Interlaken Engineering and Design, PLLC
7001 Seaview Ave NW, Suite 160-388,
Seattle, WA 98117 | (206) 470-9572

May 26, 2021

RE: 2012-199 Comment Response

**C2**  
Drainage Site Plan  
Scale: 1" = 10'

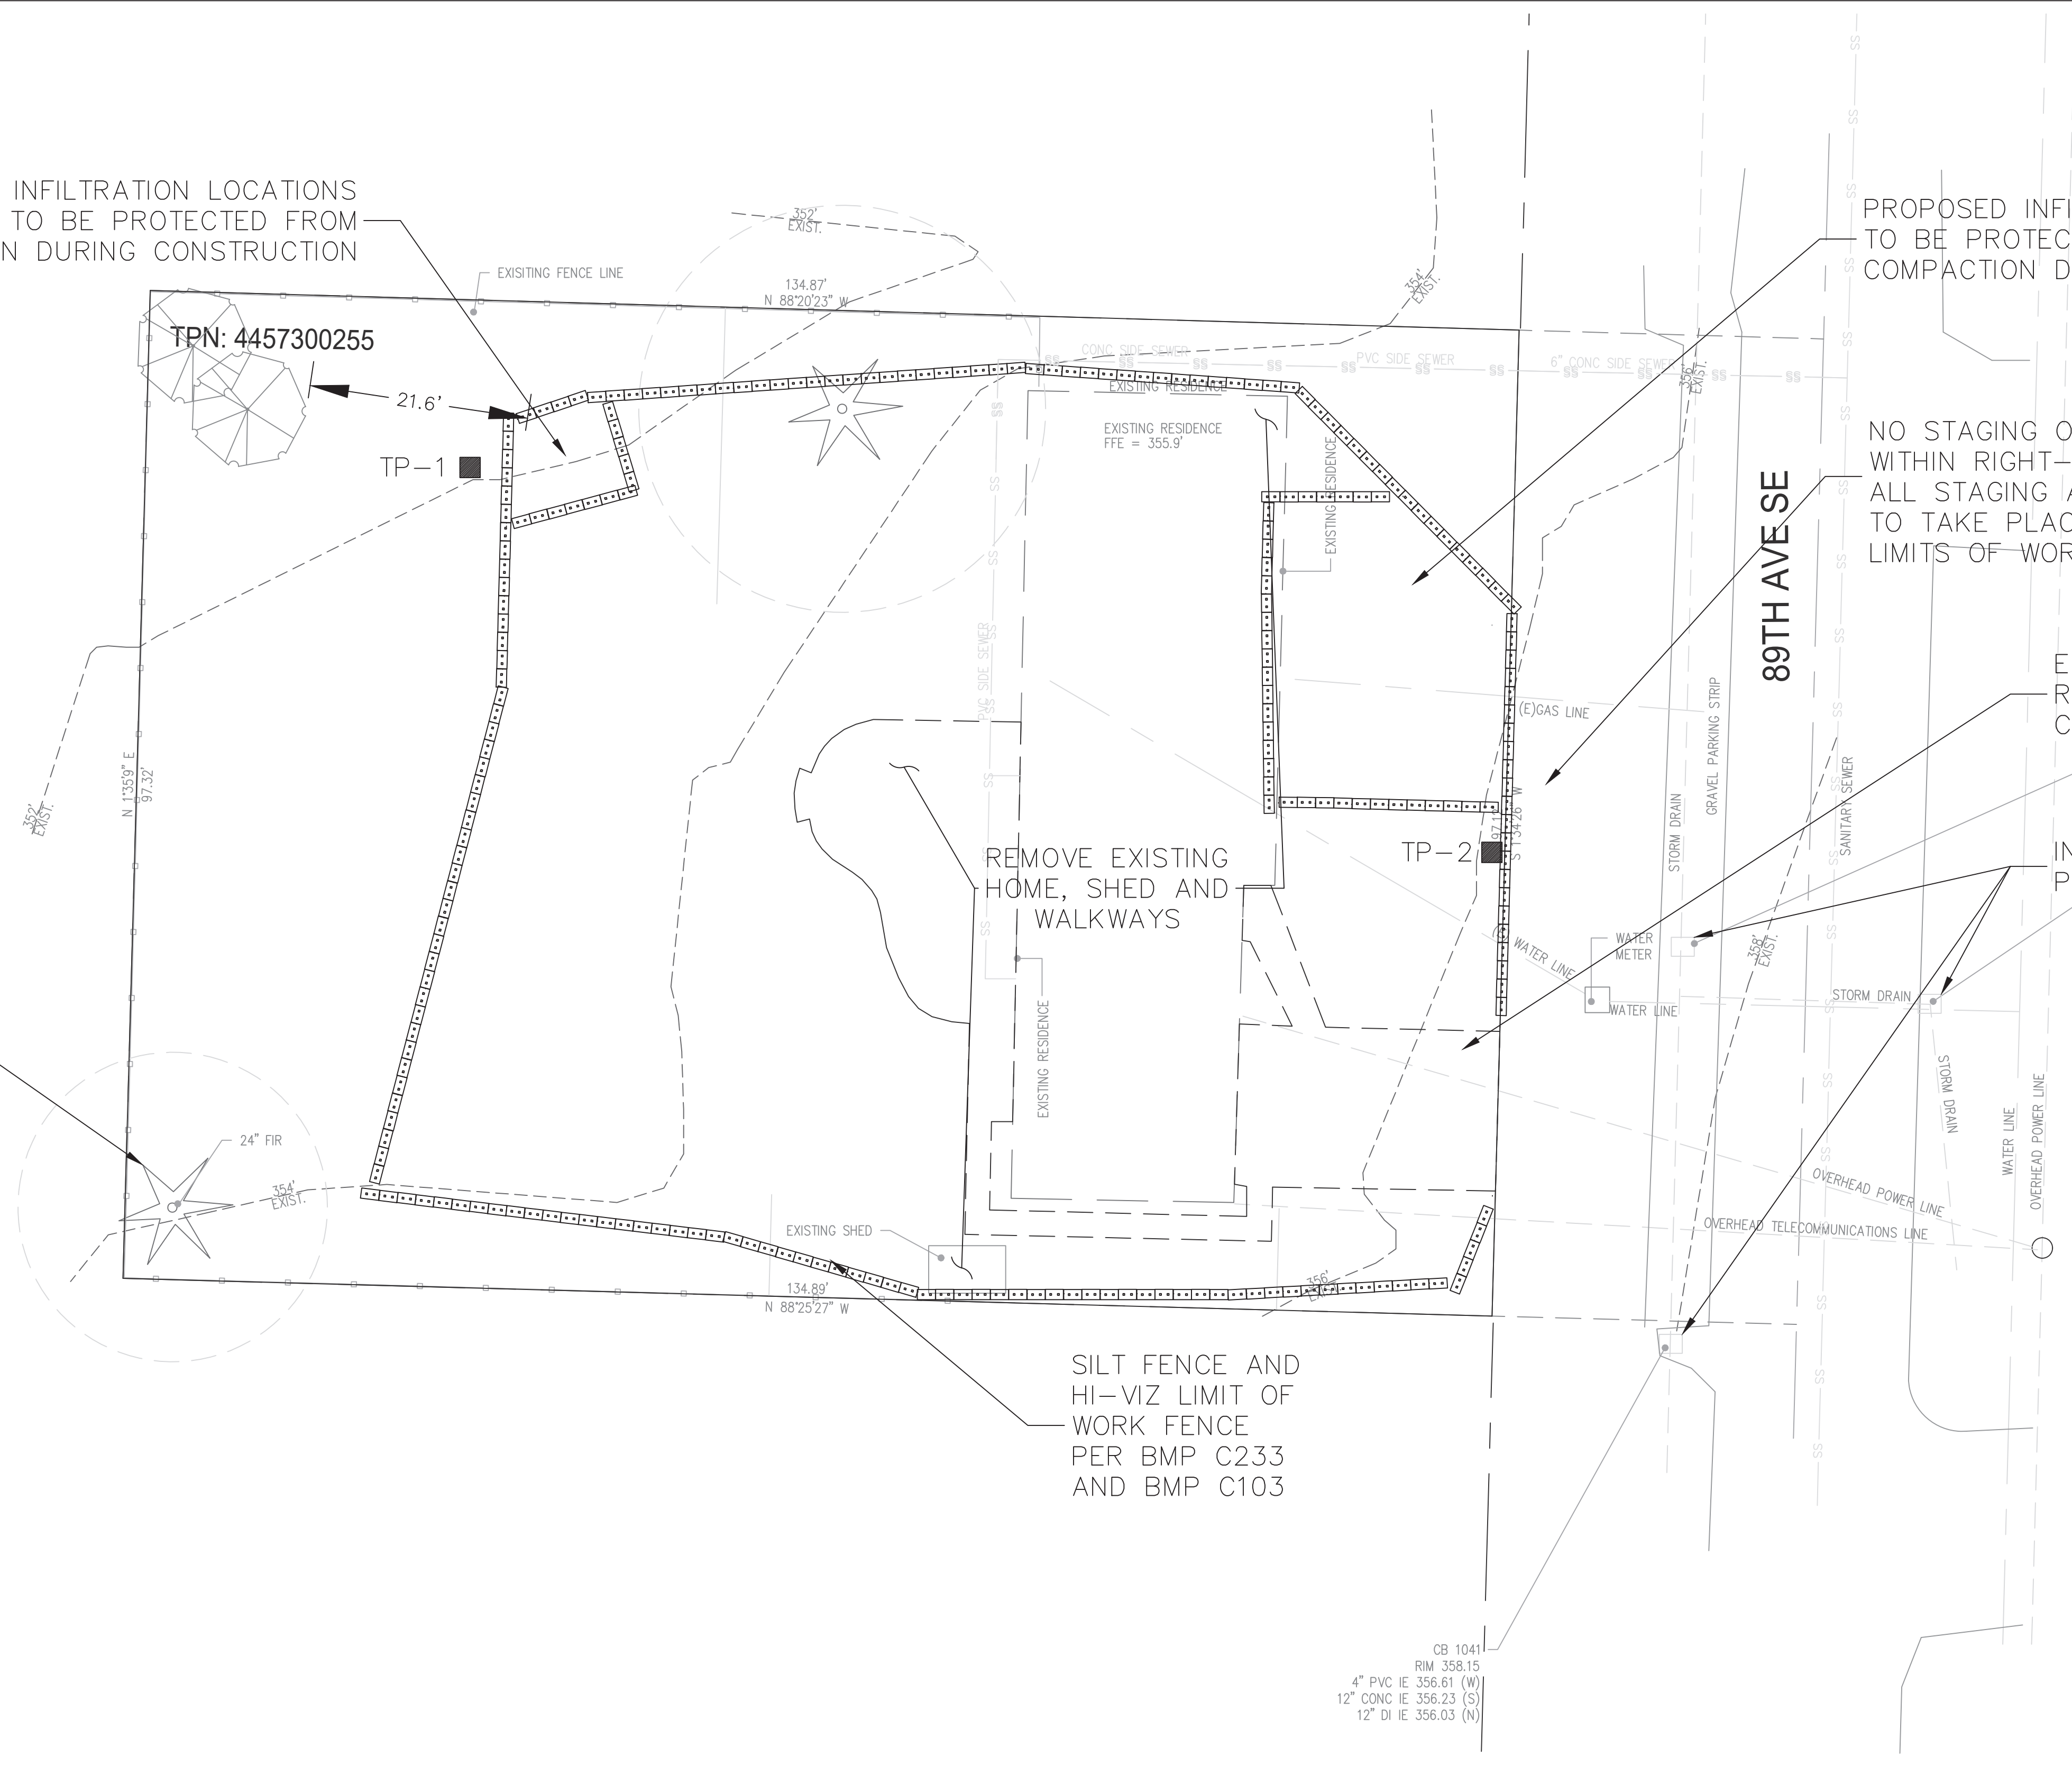
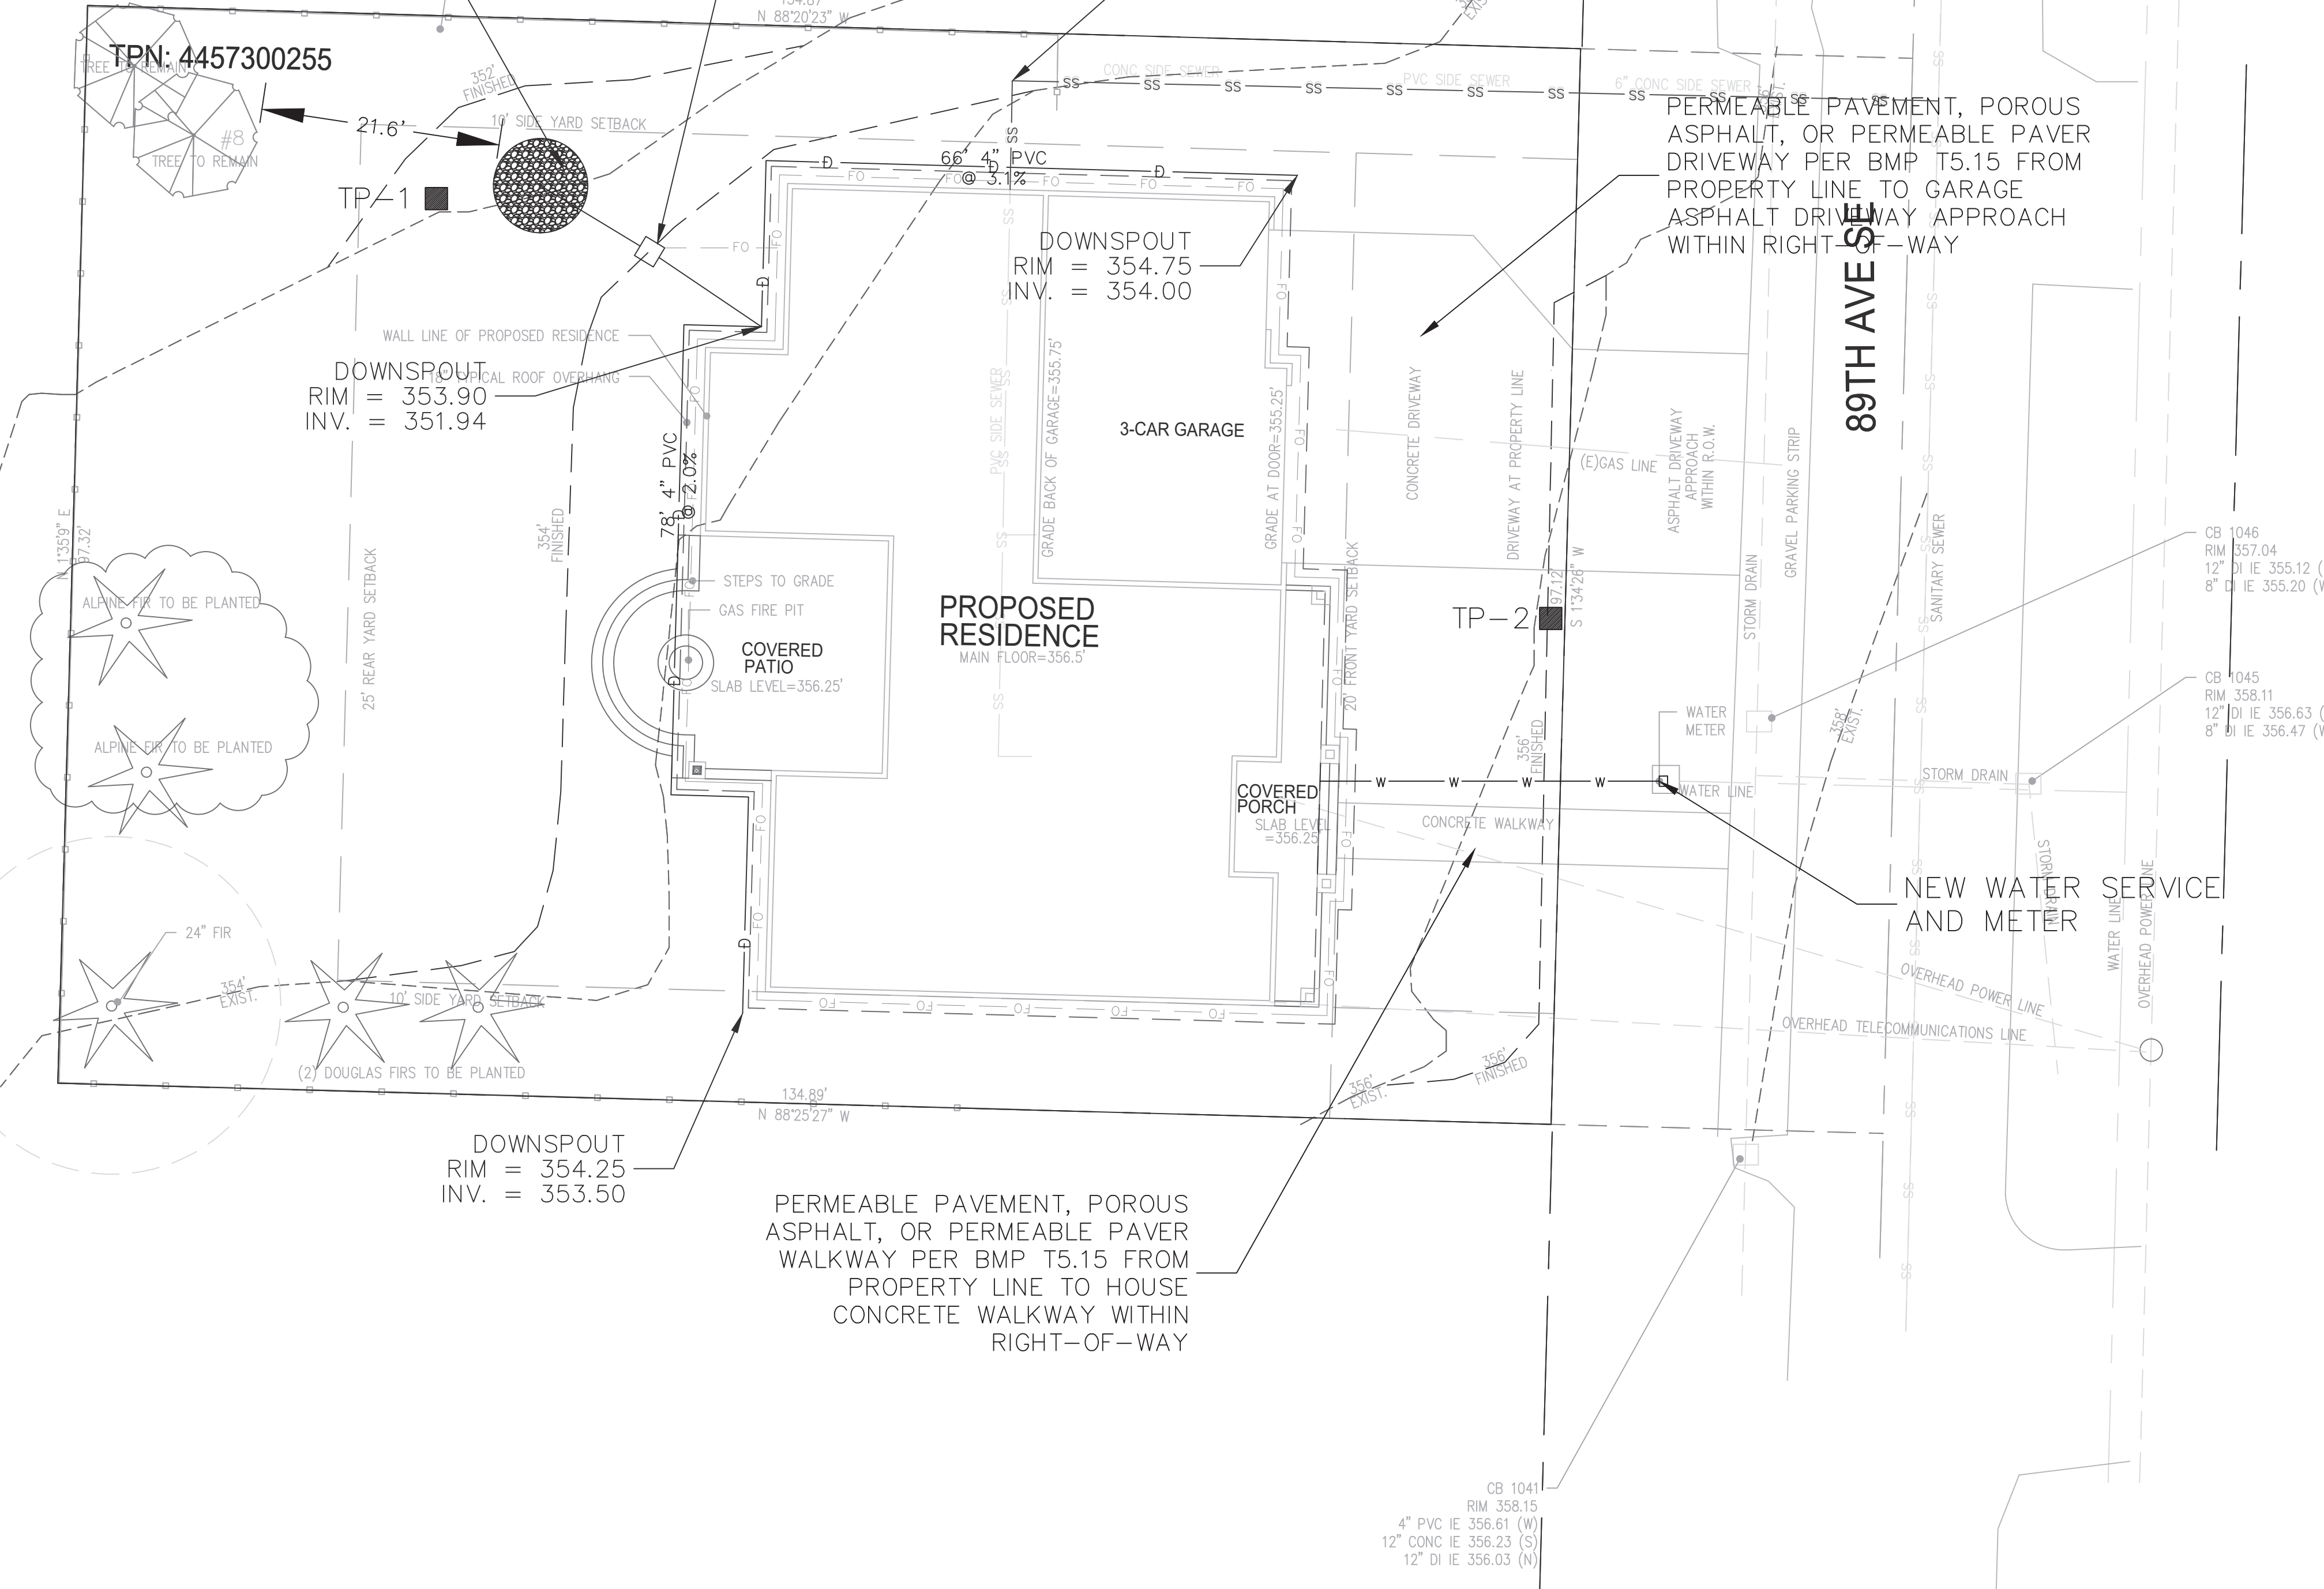
Geotechnical special inspections should be itemized on the drawings and on the Mercer Island Cover Sheet. At a minimum, we anticipate the following: monitoring of erosion control, observation and monitoring of excavation, subsurface drainage installation, soil bearing verification, and structural fill verification and compaction.

Geotechnical Special Inspections as identified in the Response to Comments prepared by Earth Solutions NW LLC dated May 21, 2021 have been added to sheets C1 and C2.
